**Planning Application No: 3/2026/0658**

**Proposal: Proposed change of use of offices from commercial, business and service (Class E(g)) to one dwellinghouse (Class C3), replacement of rear window with door and erection of new boundary treatment. Location: 21 Church Street Clitheroe BB7 2DF**

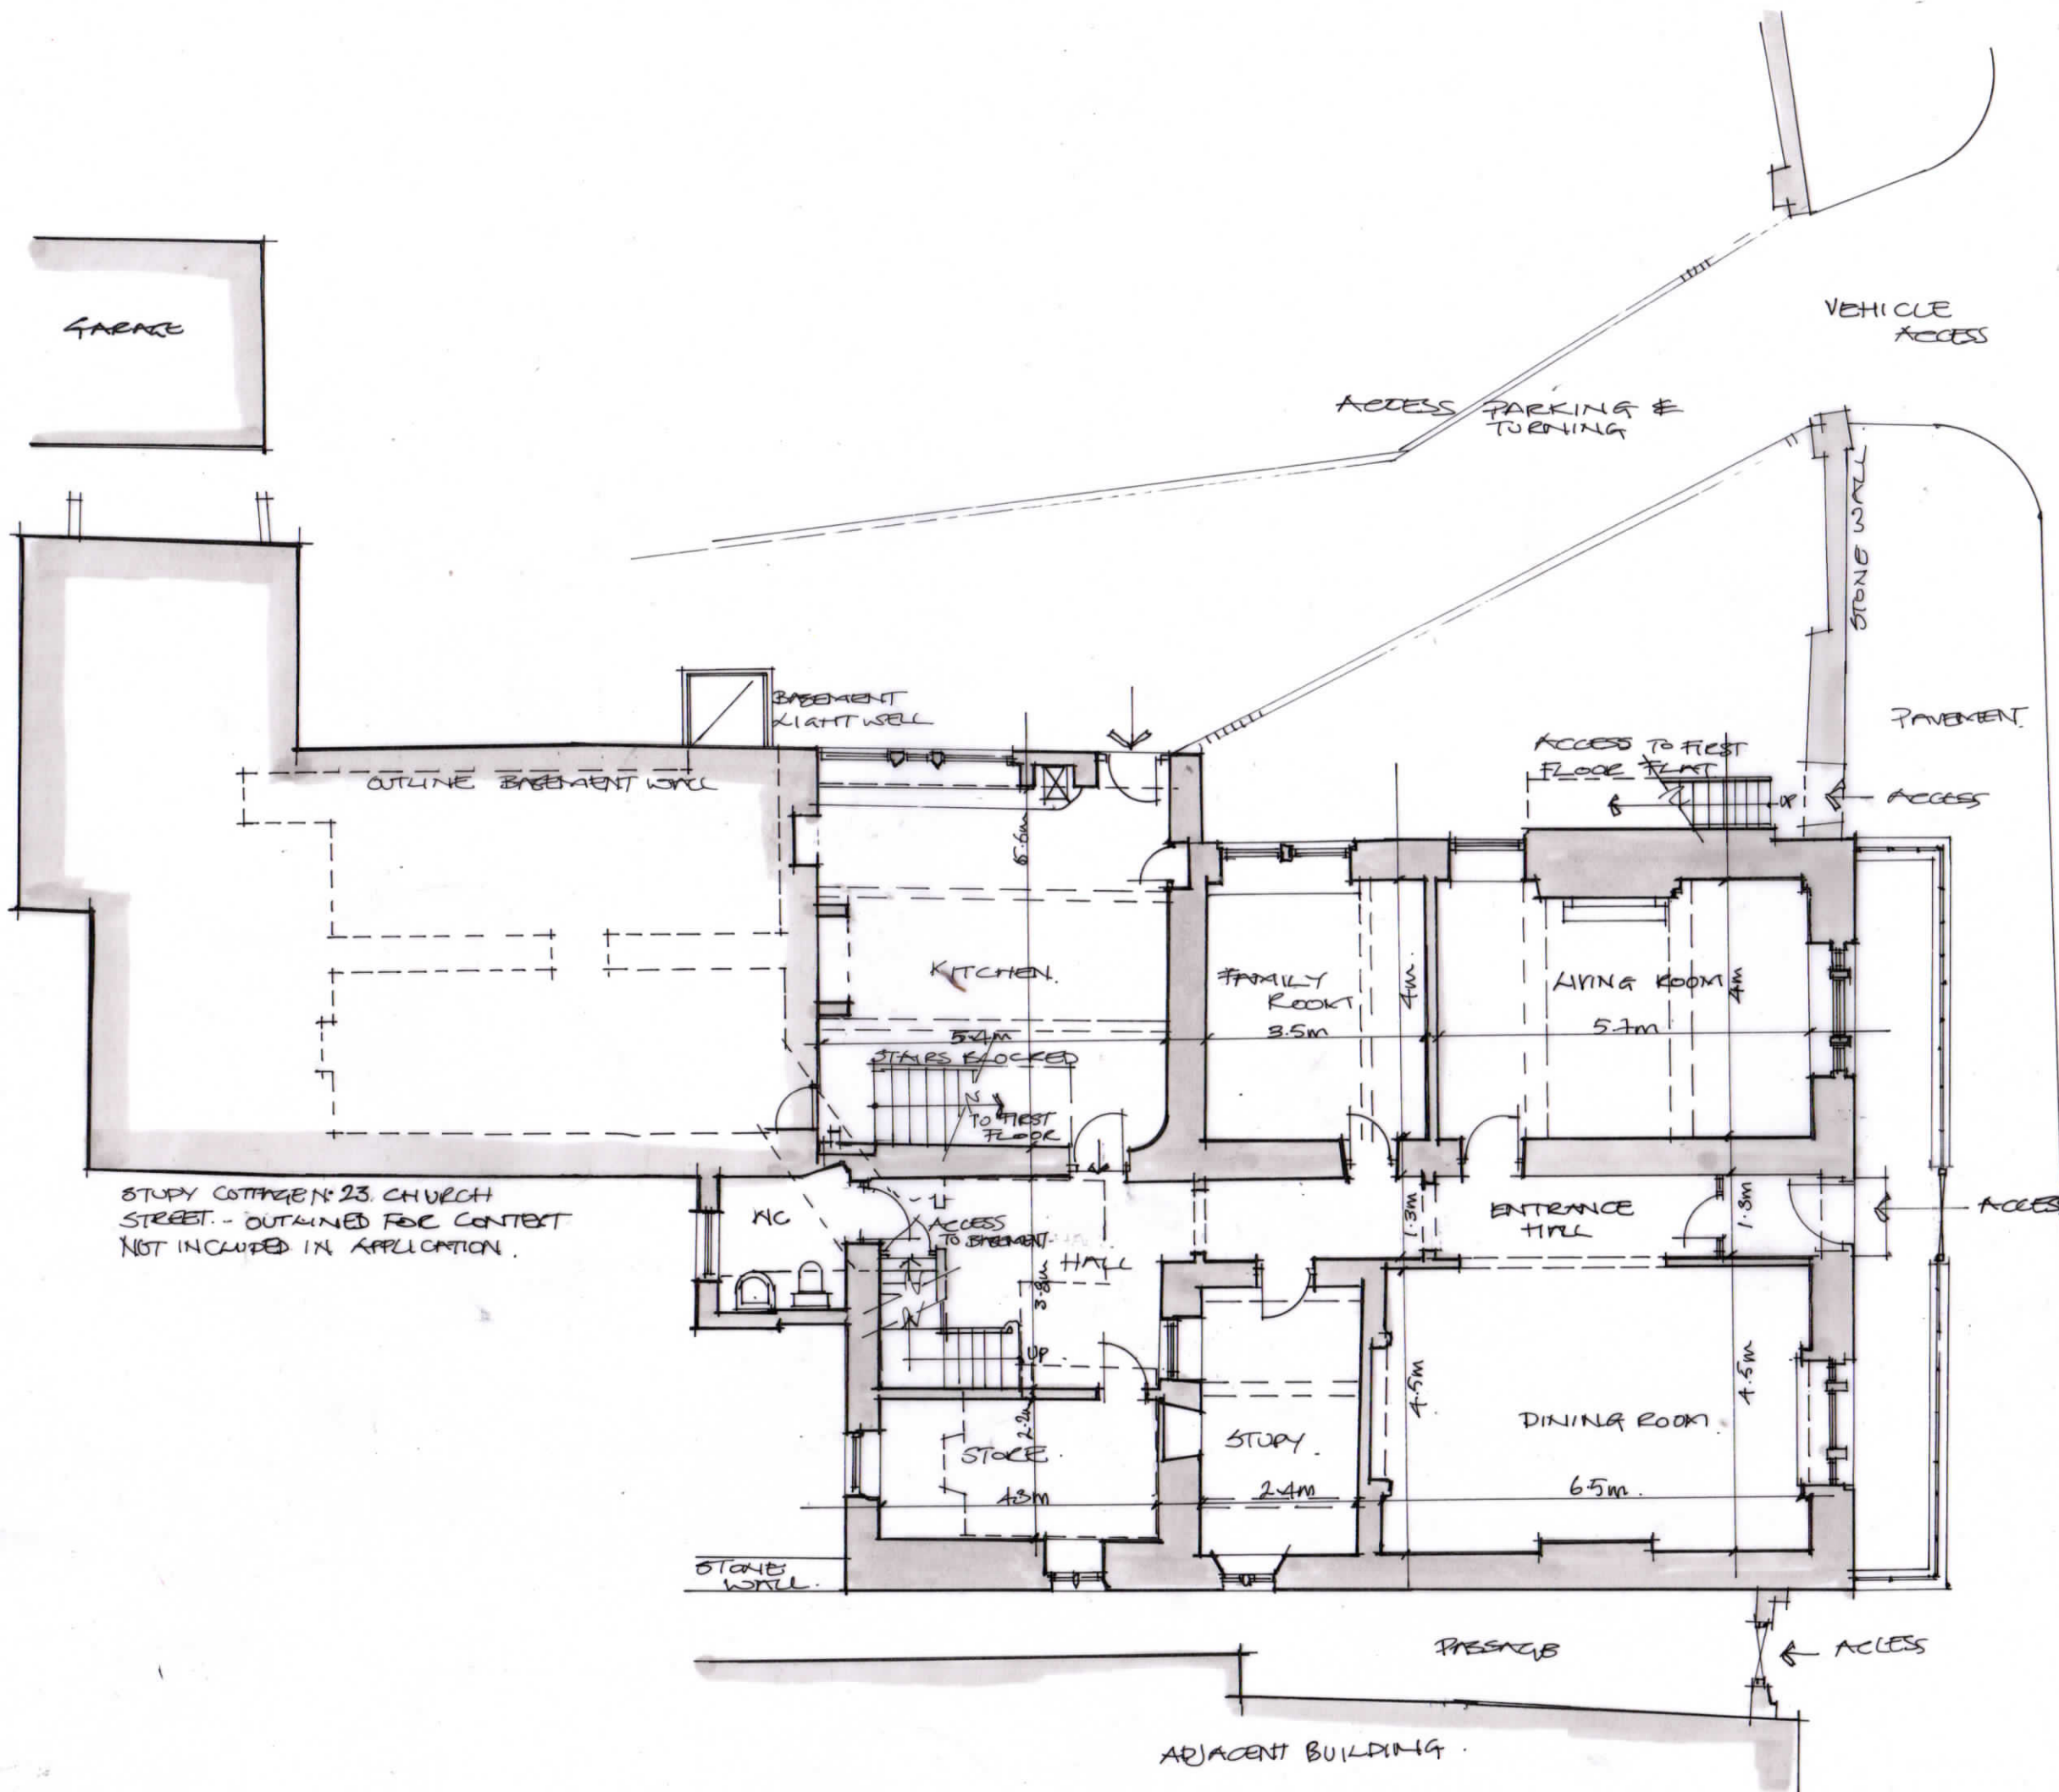
A degree of space should be retained as part of the proposal to allow for the storage of refuse bins, whilst retaining pedestrian access. As a result, this should avoid refuse migrating and ultimately being left on the adopted street.

- A degree of yard space should be retained as part of the proposal. This should be adequate to allow for the storage of refuse bins, whilst still maintaining limited pedestrian access. As a result, the retained area should avoid refuse migrating and ultimately being left on the back street.

No part of the development hereby approved shall be brought into use until cycle stands or secured covered cycle storage space have been approved for 4 pedal cycles.
